# Waddington Parish Council

Application number 3/2012/0938,

26 Waddow Grove, Waddington, Nr Clitheroe Lancashire BB7 3JL.

The Parish Council would like to make a formal objection to the above planning application on the following grounds:

PROPOSED DOUBLE STOREY SIDE EXTENSION.

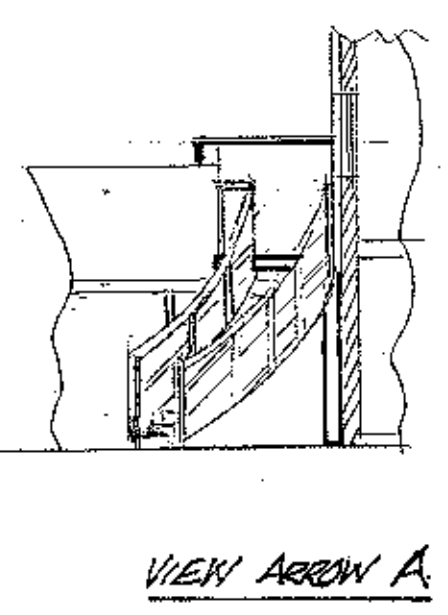
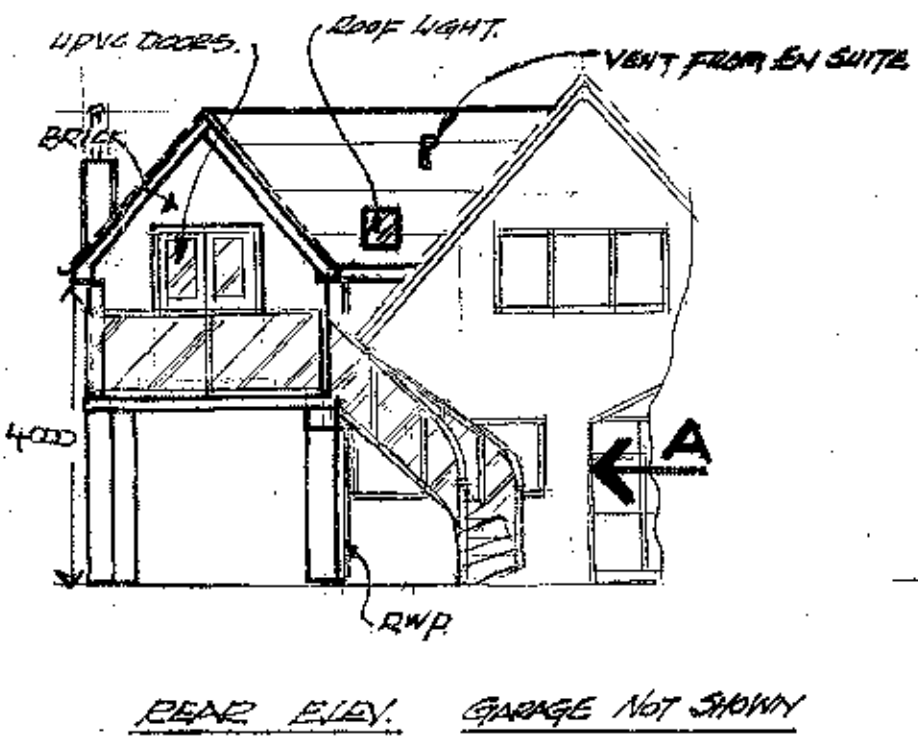
- The balcony is not in keeping with the surrounding houses on Waddow Grove.
- There are no other houses locally which have a balcony.
- It is invading the privacy of the neighbouring houses.
- It is in very close proximity to the neighbouring property
- An extension of this size would make it out of line with the other properties in the Grove.
